RE: M-51 Industrial– Response to City Comments

Please refer to our responses below which address all review comments received from the City of Marysville on September 1, 2023, regarding the M-51 Industrial submittal package. You will find the markup comments listed in the order that they were written followed by our response in *italics*.

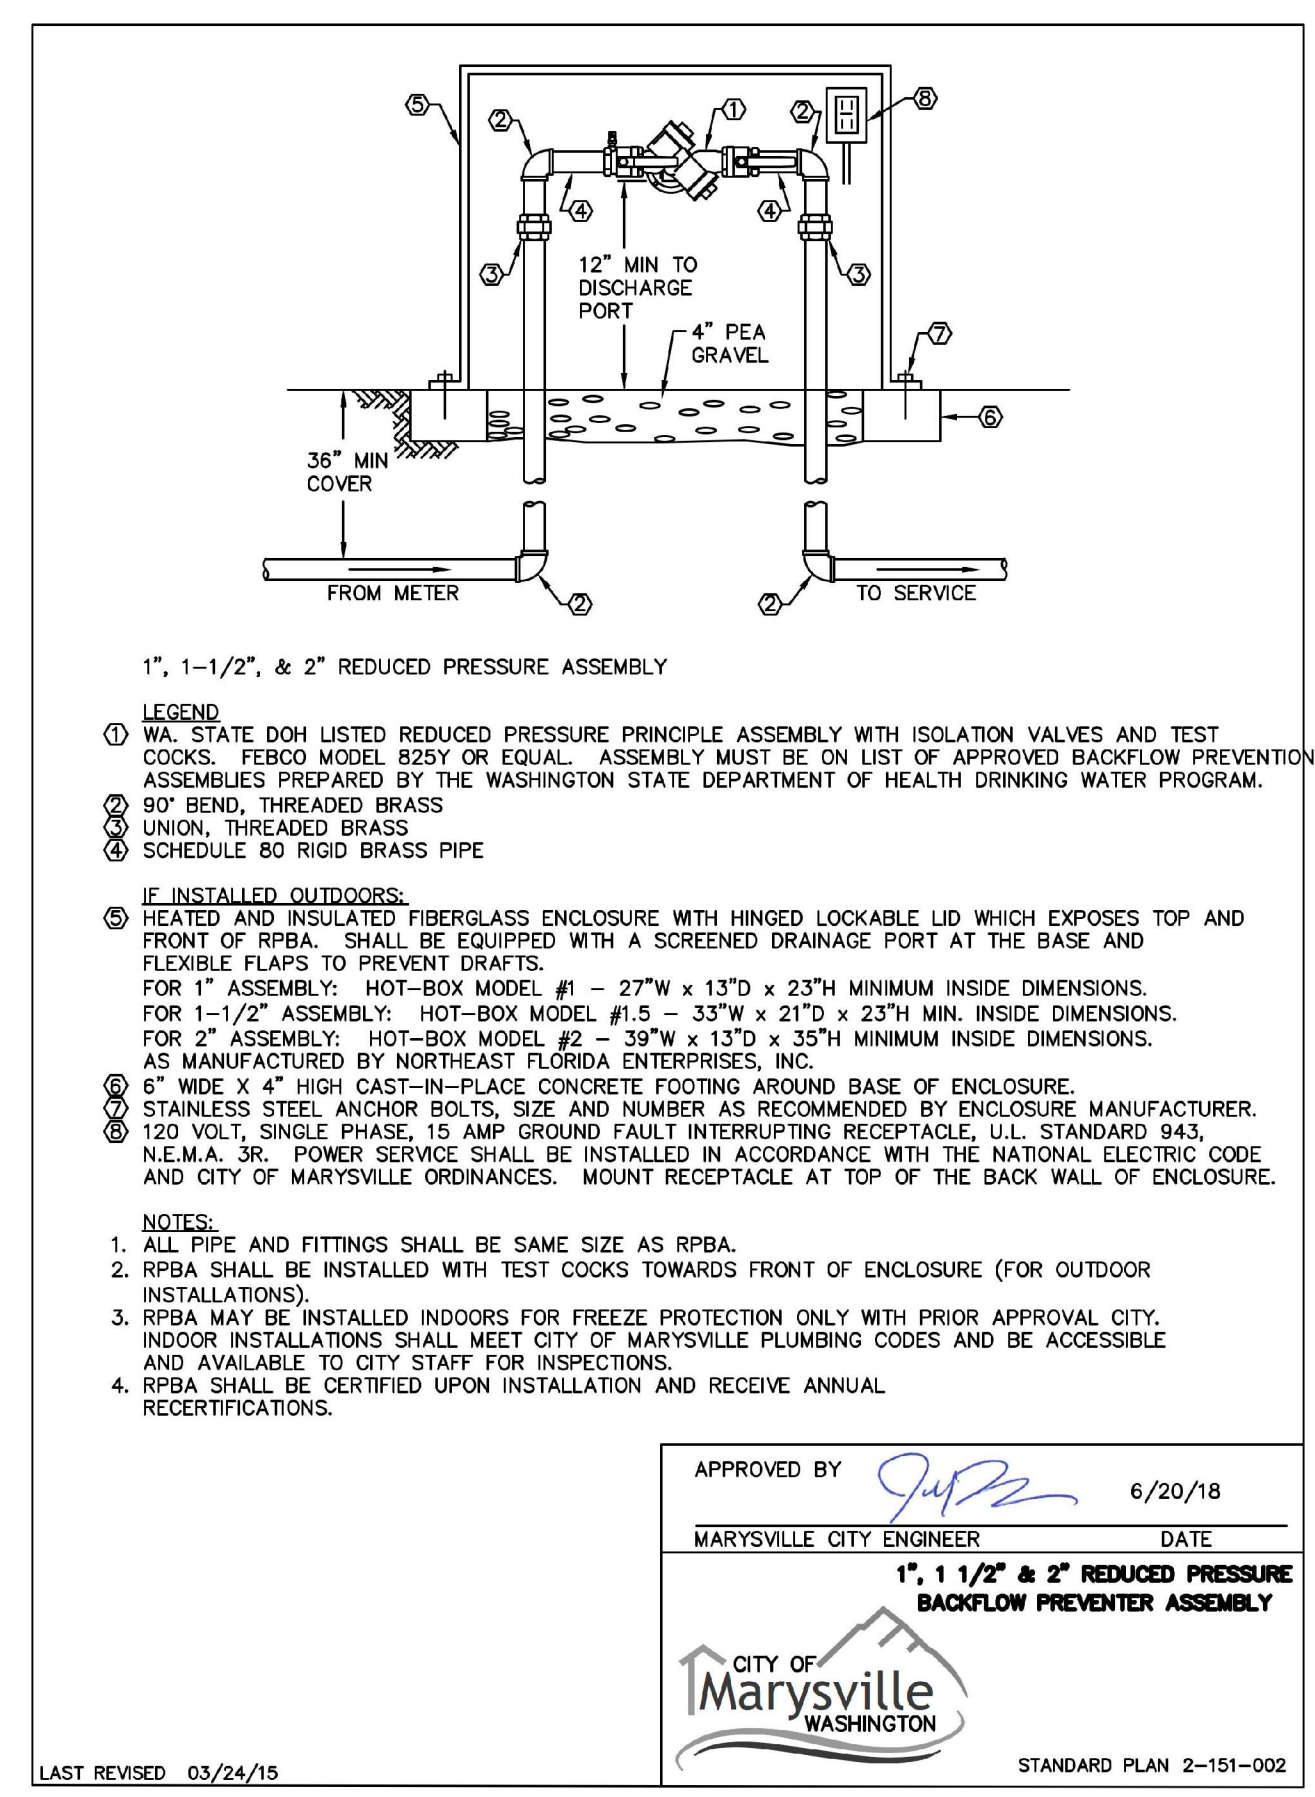
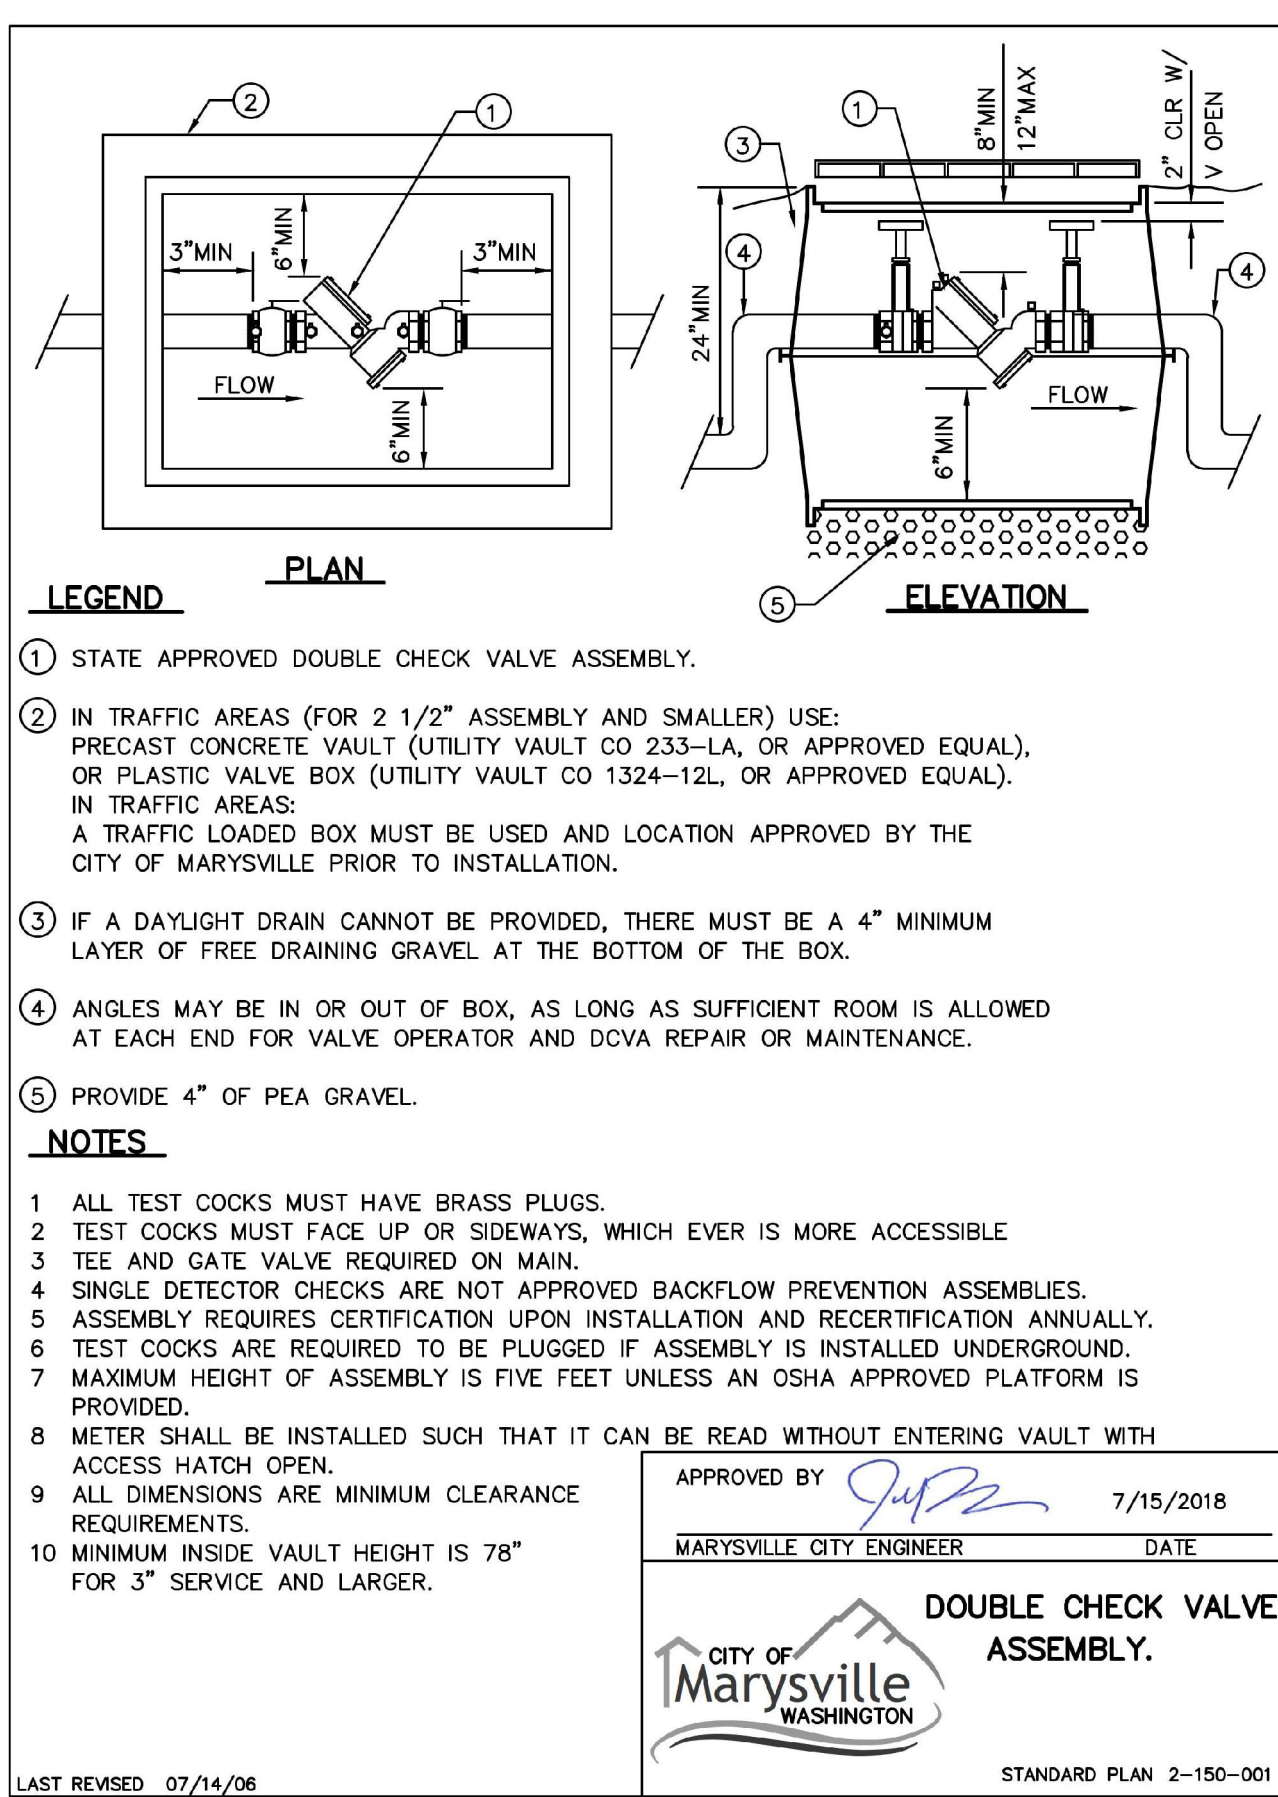
51. Water details not shown.

Response: Added water details to the plans.
